**KIRKLEES METROPOLITAN COUNCIL
INVESTMENT & REGENERATION SERVICE**

Reference No: 2020/44/90862/W

Site Address: Kingsgate Centre, King Street, Huddersfield, HD1
2QB

Description: Discharge conditions 4, 6, 8, 10, 11 on previous
permission 2018/93568 for change of use of existing
unit in a mixed Class A1/A2/A3 retail development to
form a mixed A1/A2/A3/A4/D2 retail and leisure
development, internal alterations and reconstruction of
upper level, with extension, external slide and
formation of roof terrace for use as sky bar

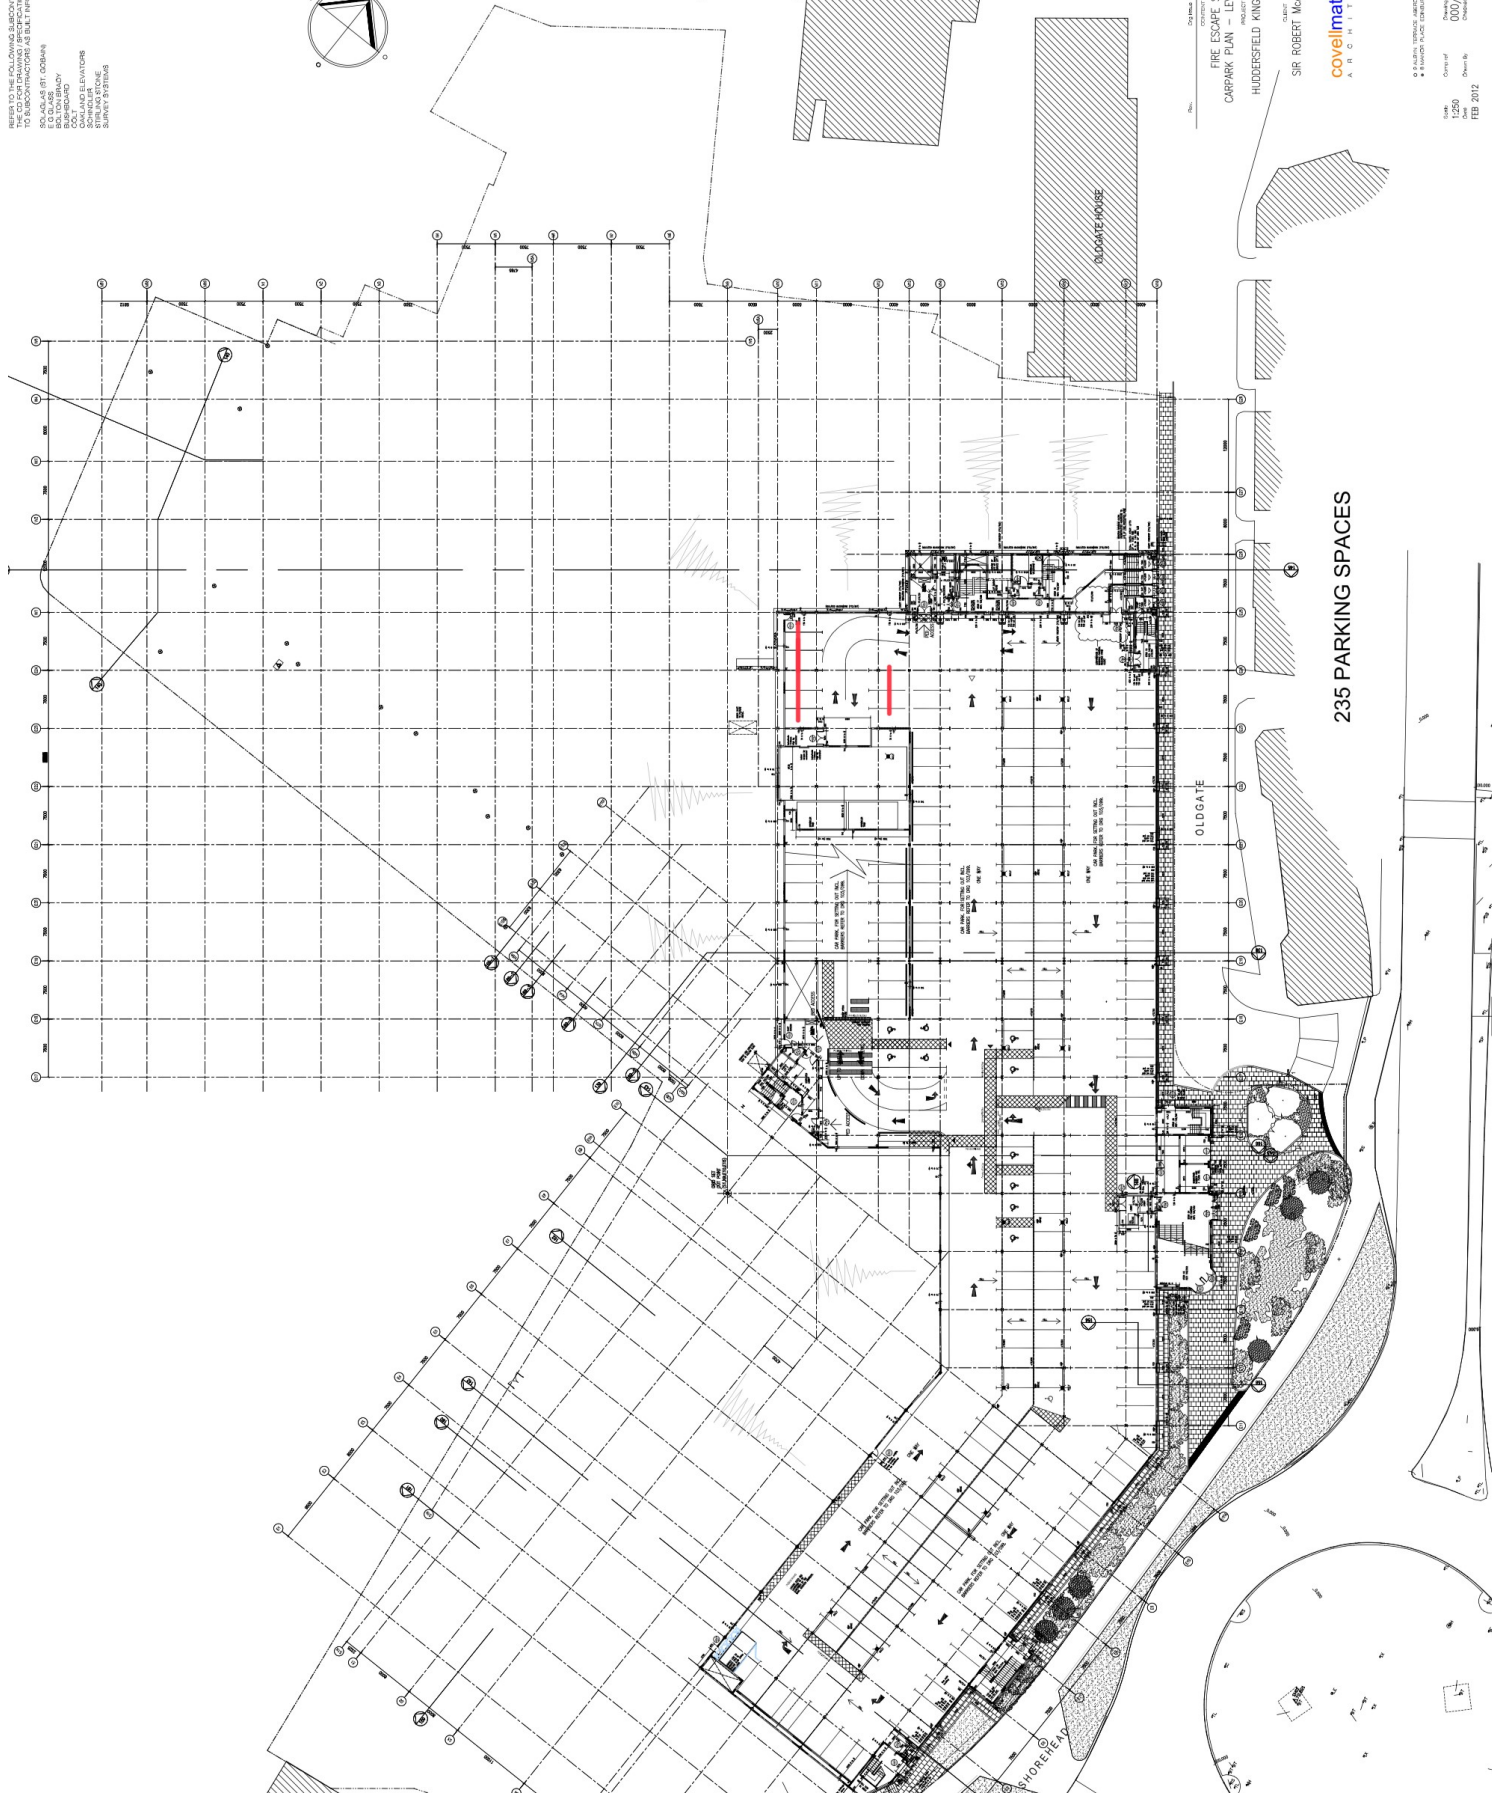
The applicant is proposing 8 charging points. 5% of 176 is 8.8, so officers consider it more appropriate to round to 9. They have also failed to propose a trigger point for the remaining 5%.

Notwithstanding the above, the submitted details suggests that the 8 spaces are proposed as Fast Charge units although there is some ambiguity if this is the case or that they could be accommodated. 8 Fast Charge units are considered more beneficial for a shopping car park than 18 standard charging points, given the high turnover such parking spaces would have.

Officers are to put it back to the applicant to clarify and confirm that 8 Fast Chargers capable of a delivery of 22kW is proposed and feasible. If not, officers will seek 9 standard charging points and agreement of a trigger point for the additional 9 units.

In addition, no details of how the use of the parking spaces served by the EV charging points will be managed has been given. This should show how these parking spaces will be available for use for charging electric vehicles and not be used for vehicles not being charged.

Officers accept the logic of 176 parking spaces as a starting point. However, officers would round 5% of 176 (8.8) to 9 units. Furthermore, there is no proposed trigger point for the remaining 5% of units.

Notwithstanding the above, the proposed 8 units are shown to be two different chargers that are each capable of providing a nominal 22kW per charging point. The use of Fast Charge units for the site, being a retail car park, is welcomed over slower alternatives. If it can be confirmed that all 8 units are to be 22kW units and would operate at their maximum speed, no additional charging points are sought.

It is understood that the car park is managed and that users are subjected to parking fees. It is therefore assumed that the parking bays served by the EV charging points will be managed in a way that prevents them being used by non-electric vehicles. Confirmation of how the spaces will be managed needs to be provided by the applicant.
